PL- Rep- Barnham & Eastergate Parish Council response

From: Planning [REDACTED]
Sent: 03 June 2026 07:31
To: Planning.Responses <Planning.Responses@arun.gov.uk>
Subject: Re: Planning Consultation on: BN/57/26/HH

Application No:	BN/57/26/HH
Registered:	13th May 2026
Site Address:	43 Elm Grove Barnham PO22 0HL
Grid Reference:	495469 105213
Description of Works:	Erection of single-storey extension to front elevation of existing dwelling.

FOR MR S. DOWNES		
SITE 43 ELM GROVE, BARNHAM, WEST SUSSEX. PO22 0HL		
TITLE PROPOSED EXTENSION ELEVATIONS		
SCALE 1:100	DRAWN AH 02/26	DRAWING NO. 06 REV B

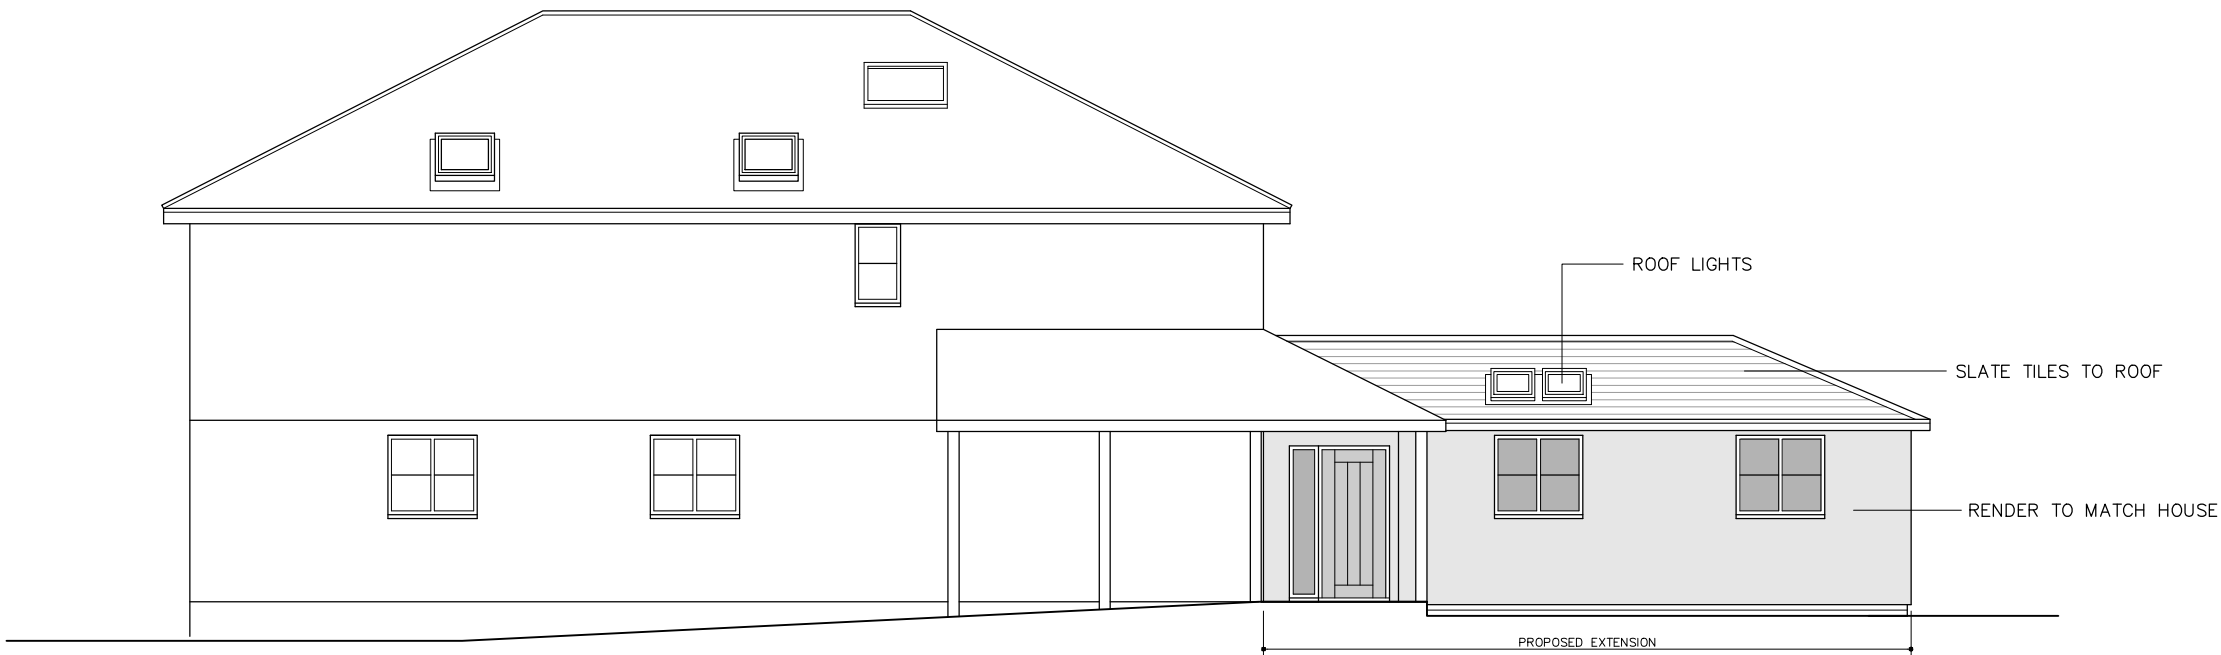
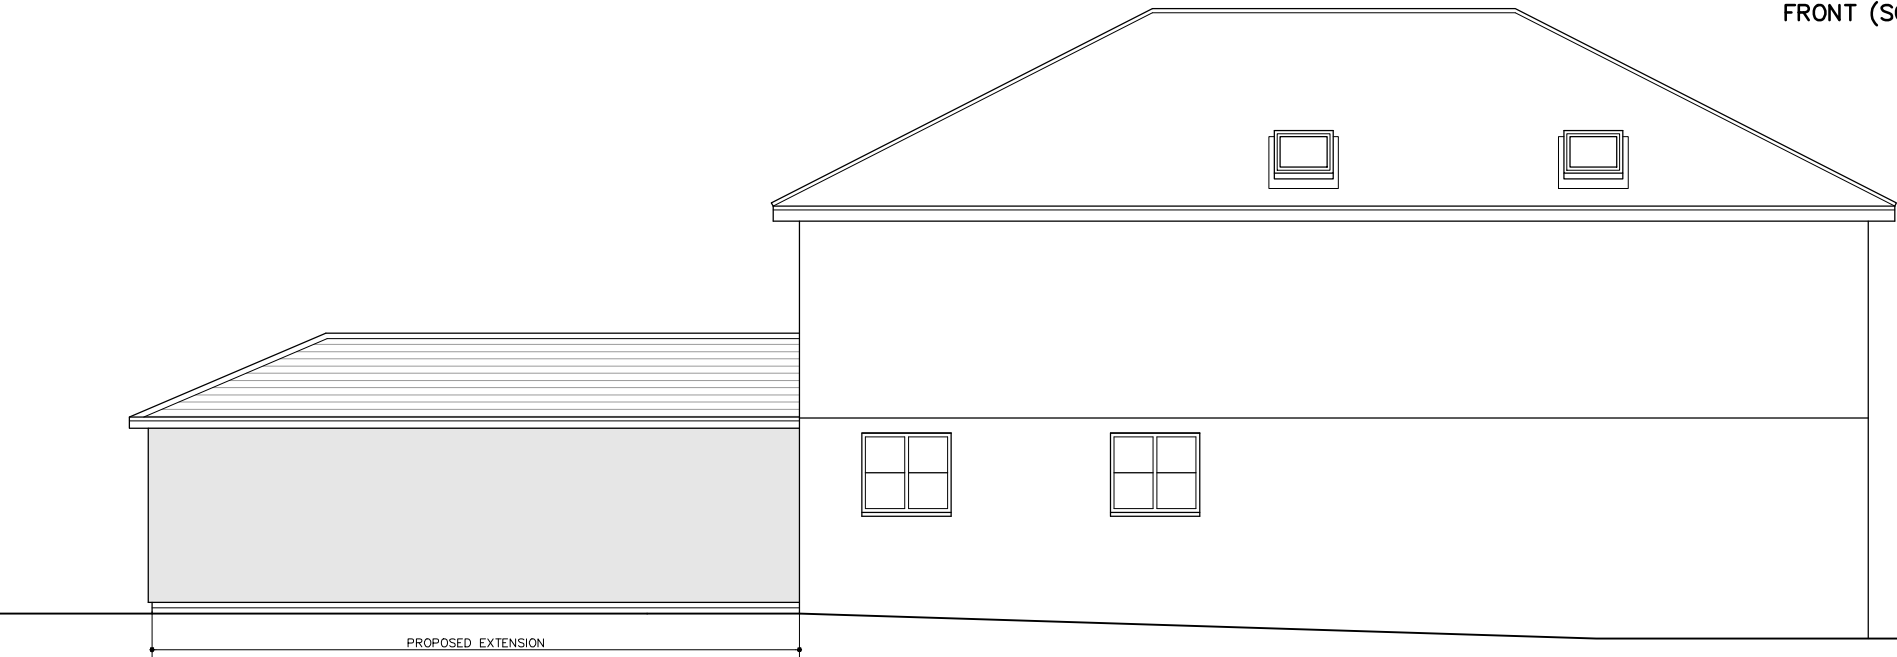
Due to the historic surface water drainage problems in this area, the committee are of the view that the proposed development, which would be built over the existing permeable drive, would have a negative impact on the already insufficient system capacity. This is due to the surface water drainage system at Elm Grove joining to the trunk main from which there have been previous regular problems and goes against BEPC NP policies ES1a Flooding, ES1b Reducing flood risk and ES1c Sewage, (full details below).

Furthermore, the committee would like to state that they are of the view that the proposed development extends beyond the established building line, is not in keeping with the local area and would negatively impact the street scene. This is not in line with BEPC NP policy ES5 Quality of design, (full details below).
